# Rezoning Transportation Analysis

Petition Number: 2023-023

Date	Description
7-26-23	First Review (IW)
11-27-23	Second Review (DR)
2-21-24	Third Review (ME)

SHEET NUMBER: RZ2-00

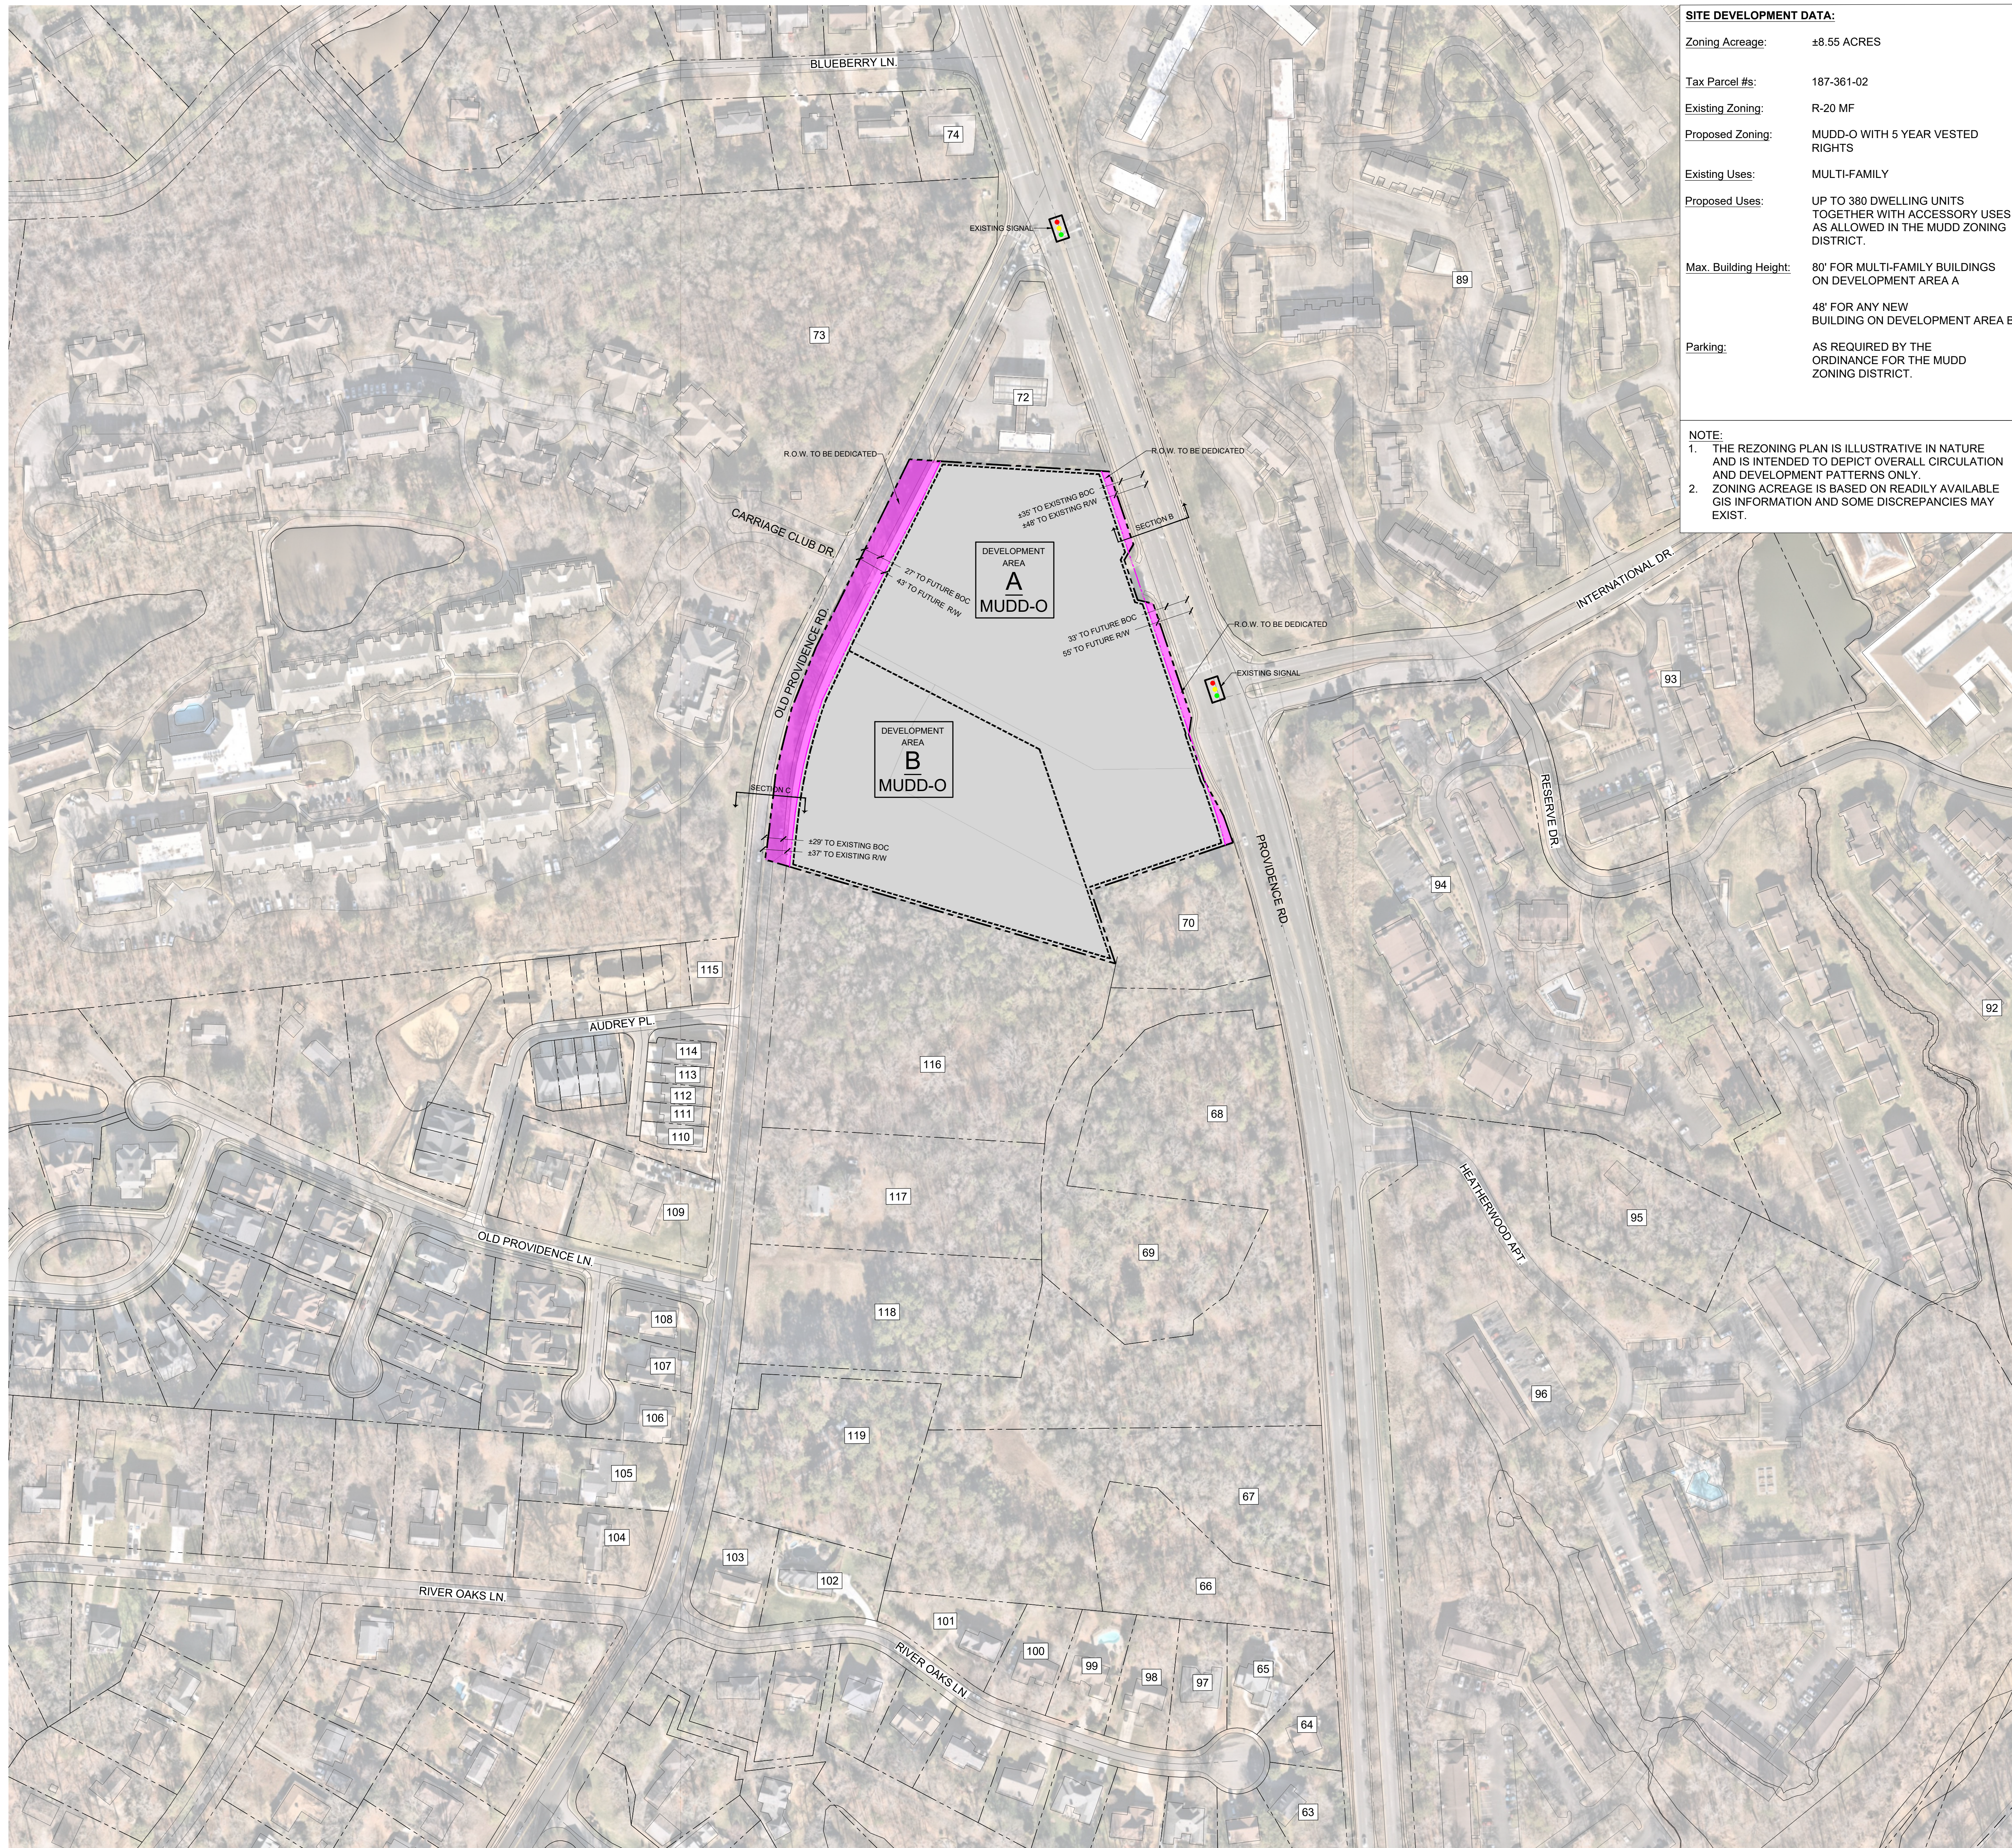
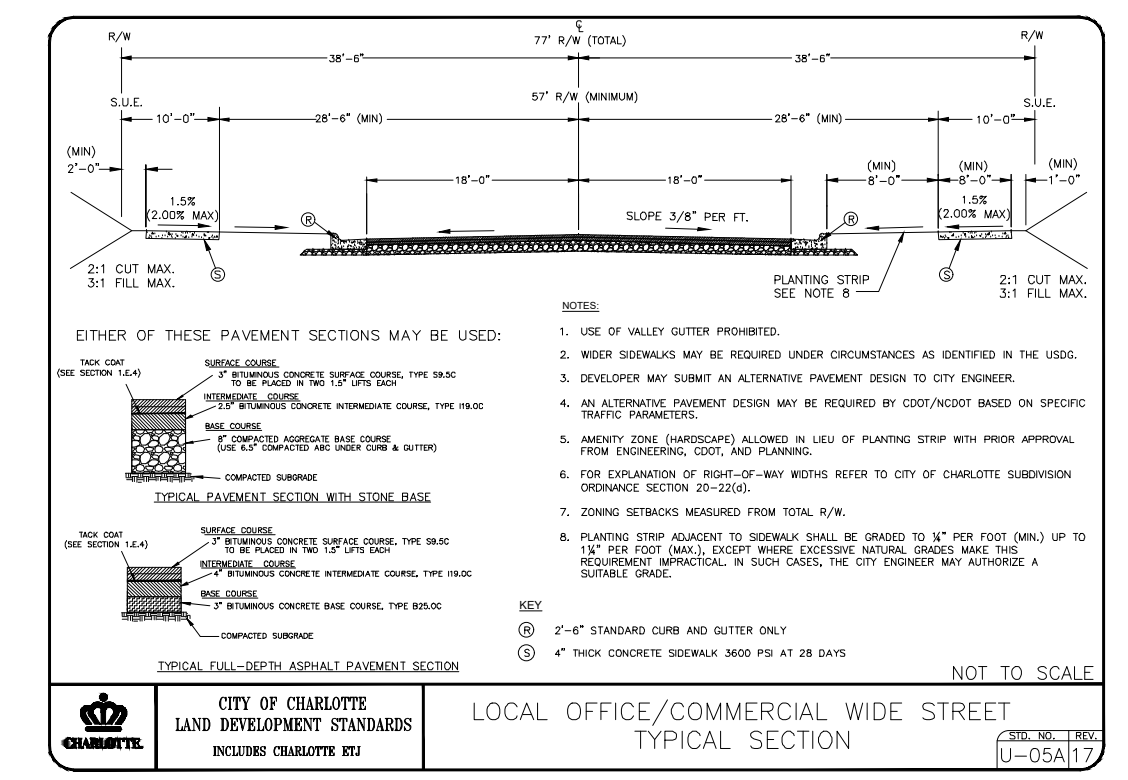
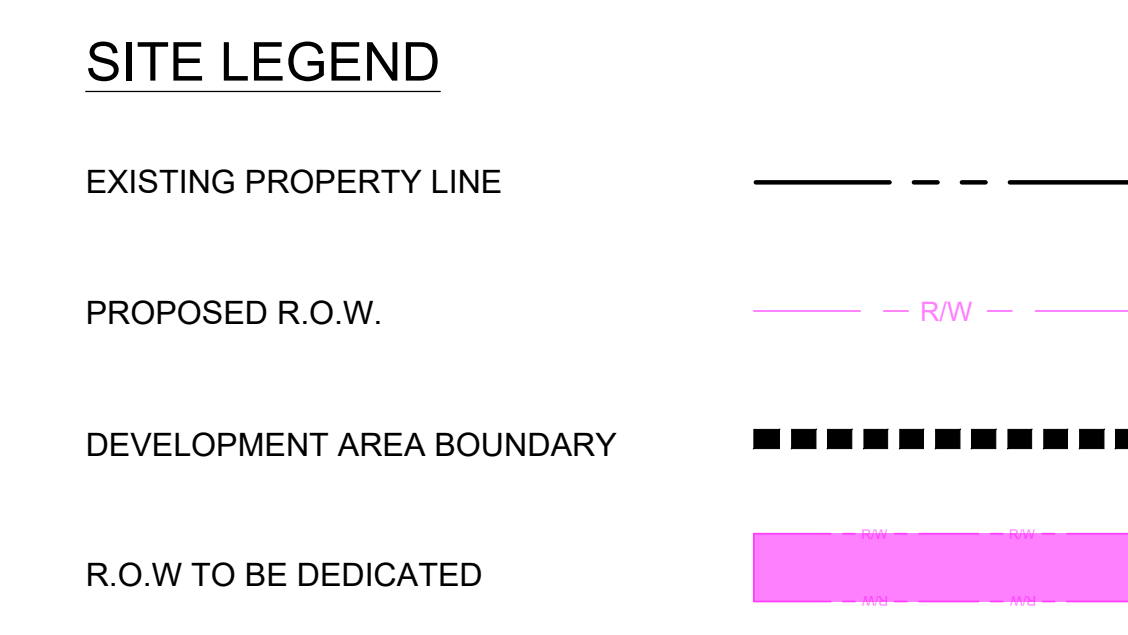
**New Comment 11.27.23:** Section C public street network sidewalk width does not match the conditional note. Revise Section C to have an 8' sidewalk like the conditional notes for the Old Providence Road section.
